OXFORDSHIRE COUNTY COUNCIL'S RESPONSE TO CONSULTATION ON THE FOLLOWING DEVELOPMENT PROPOSAL

Application no: 22/03873/F

Proposal: Installation and operation of a renewable energy generating station comprising ground-mounted photovoltaic solar arrays and battery-based electricity storage containers together with a switchgear container, inverter/transformer units, Site access, internal access tracks, security measures, access gates, other ancillary infrastructure and landscaping and biodiversity enhancements.

Location: Land North And Adjacent To Mill Lane, Stratton Audley

MSSP1362A: Stratton Court Barn, Bicester  
 Figure 8 - Magnetic Interpretation (Areas 1 - 2)  
 1:1,500 @ A3  
 Copyright Magnitude Surveys Ltd 2022  
 Contains Ordnance Survey data © Crown Copyright and database right 2022

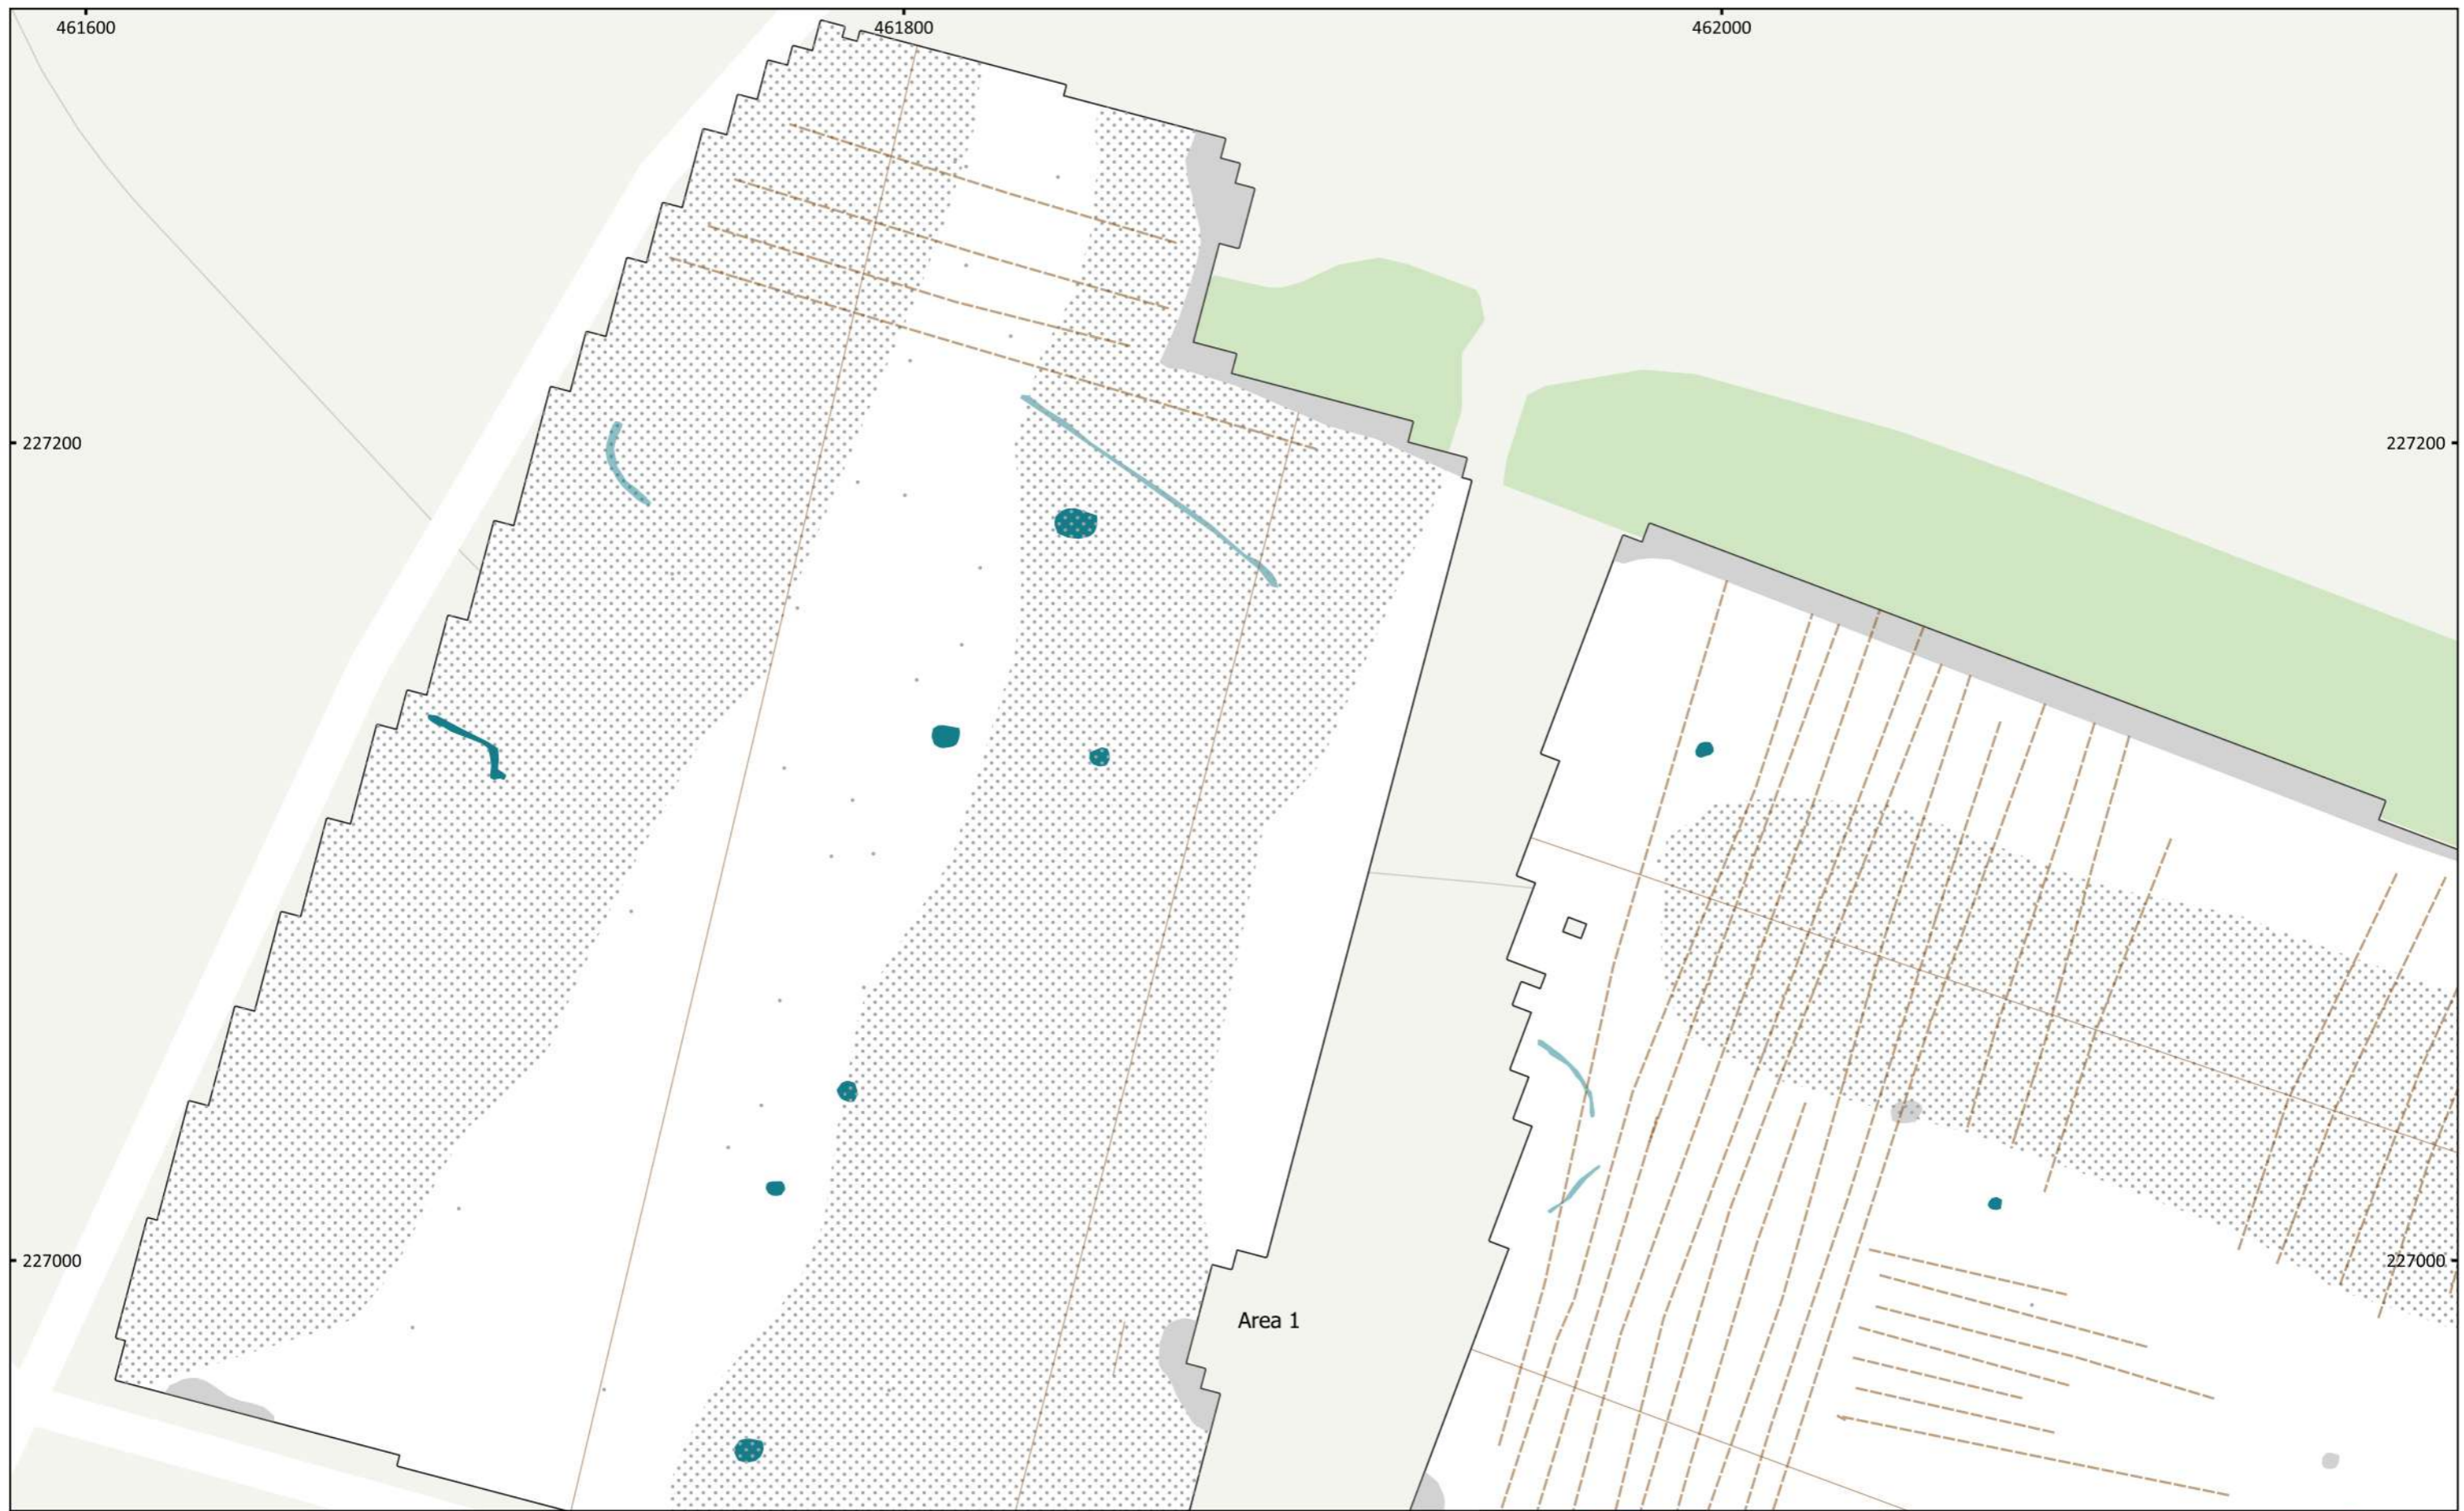
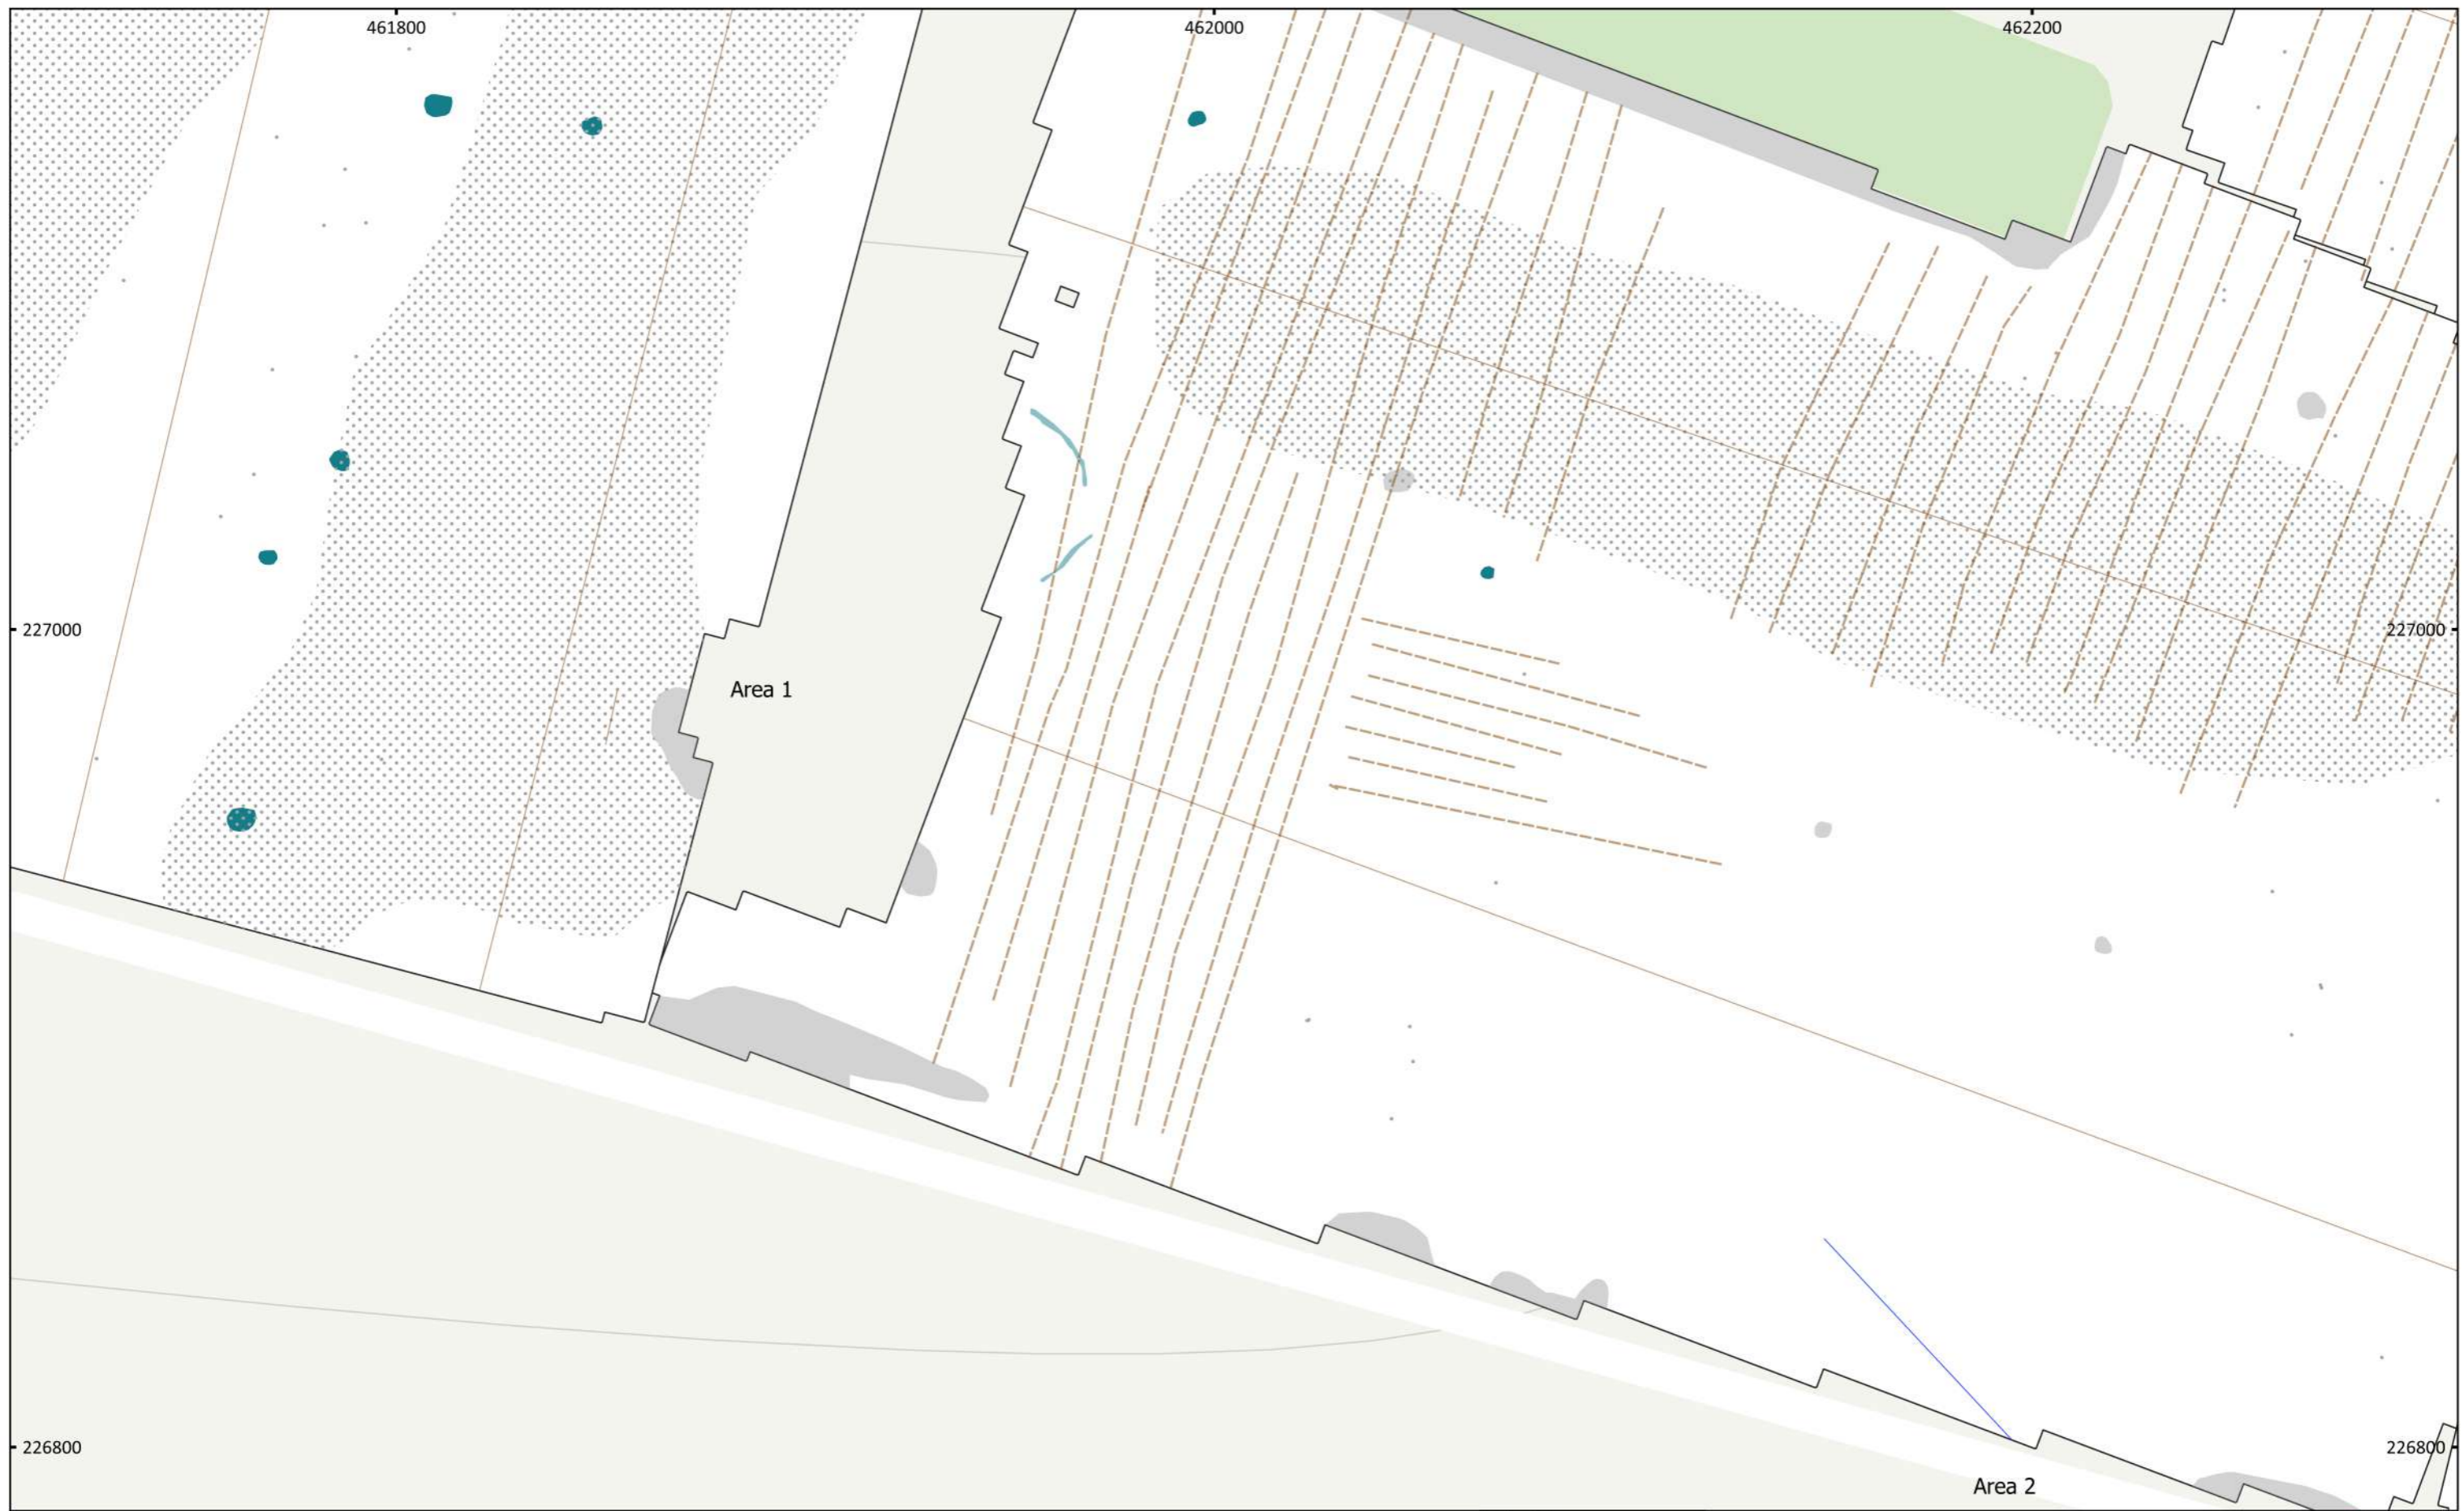
The geophysical survey and desk-based assessment carried out on the site have identified some areas of potential prehistoric activity. These will need to be investigated through a programme of pre-determination evaluation.

The site lies in an area of archaeological interest and potential, as outlined in the submitted archaeological desk-based assessment and geophysical survey report. The geophysical survey and ADBA have identified areas with potential prehistoric burning activity, and other undetermined features. These should be investigated through a trenched evaluation prior to the determination of the application.

In accordance with the National Planning Policy Framework (NPPF 2021) paragraph 194, we would therefore recommend that, prior to the determination of this application the applicant should therefore be responsible for the implementation of an archaeological field evaluation.
